Our Ref: M/26/18/HH
Your Ref:

Town & Country Planning Act 1990 (as amended)
Town & country Planning (Development Management Procedure) (England) Order 2015
Application for Planning Permission for Works or Extension to a Dwelling

Development Erection of shed

Location Wish House 130 Elmer Road Middleton on Sea

130 Elmer Road, Bognor Regis, PO22 6HZ

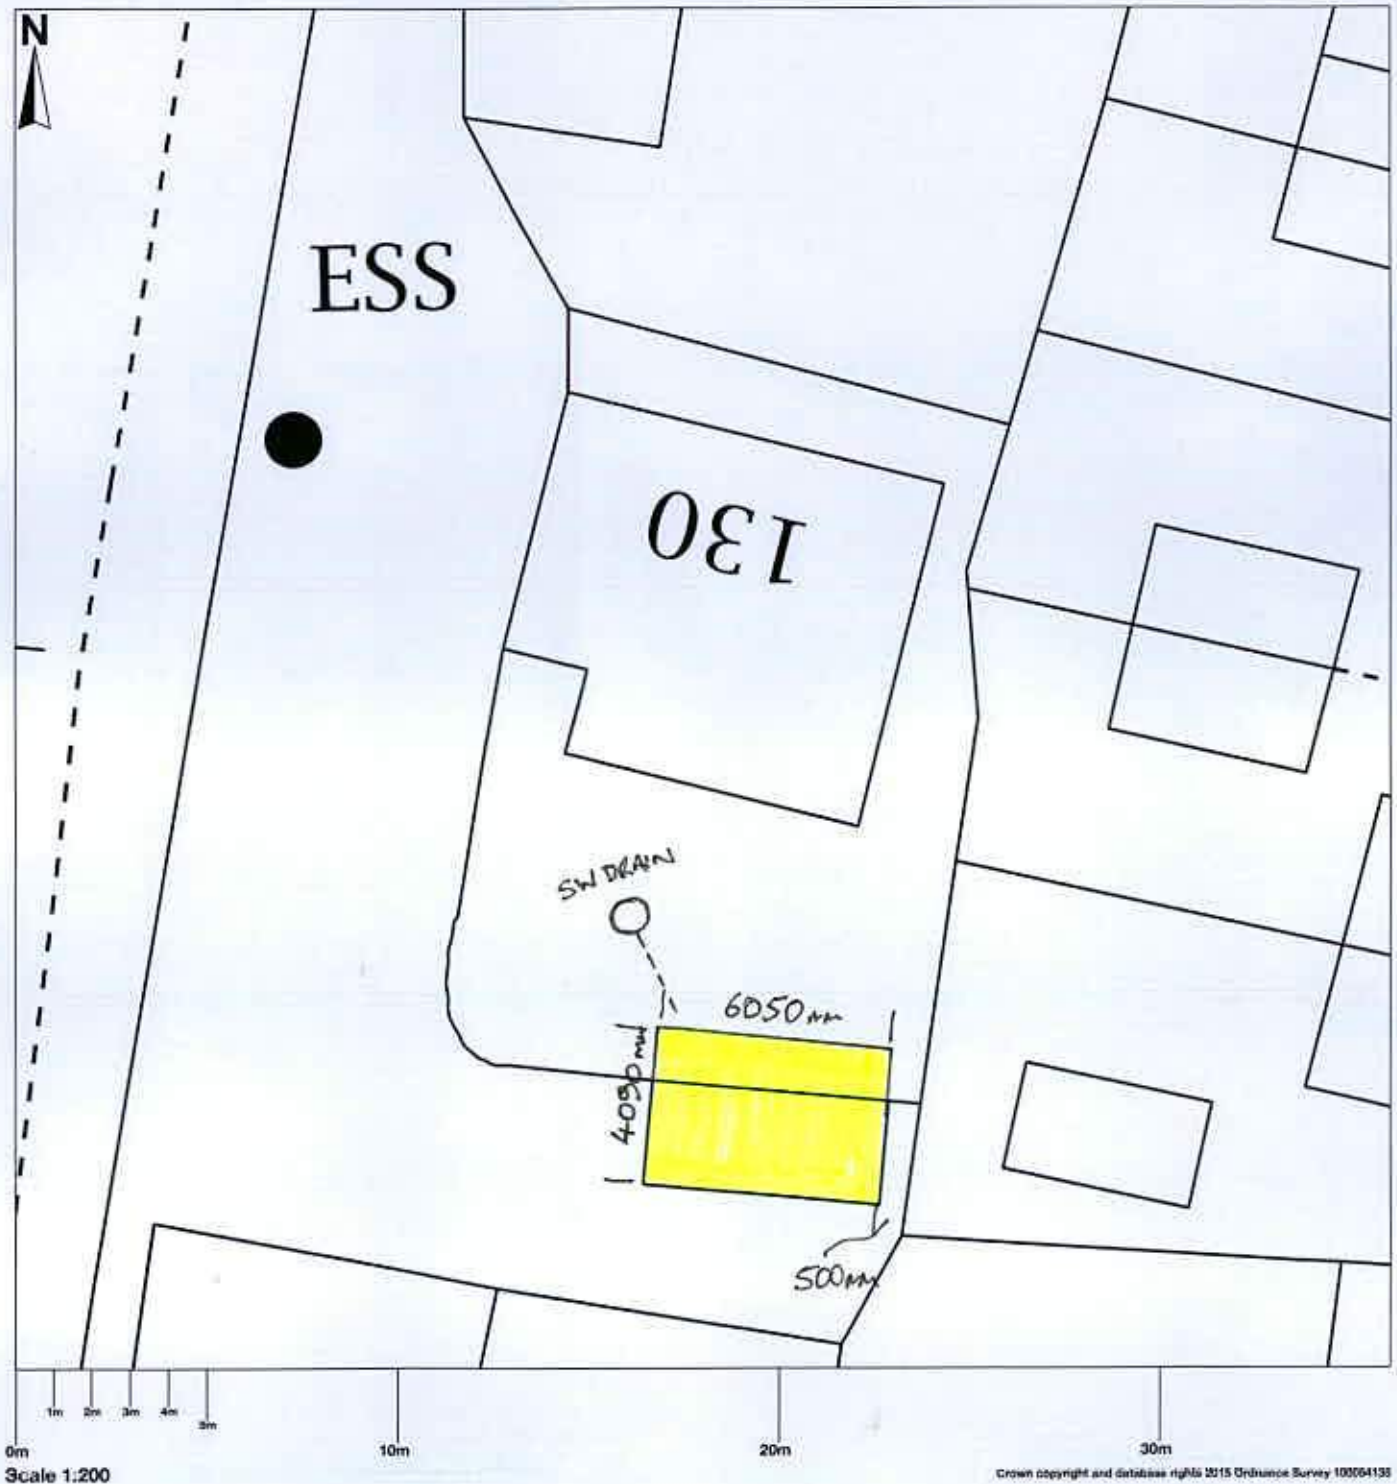
Location Plan Amend

Please submit 1 electronic or 3 paper copies of a location plan at a scale of 1:1250 or 1:2500 for rural areas. Further details of what must be included on the plan can be found in the National Validation Requirements. Please provide a scale.

Block Plan Amend

Please submit 1 electronic or 3 paper copies of a block/site plan at a scale of 1:500 or 1:200. Further details of what must be included on the plan can be found in the National Validation Requirements. Please provide a scale, a North point and dimensions from the proposal to the site boundaries.
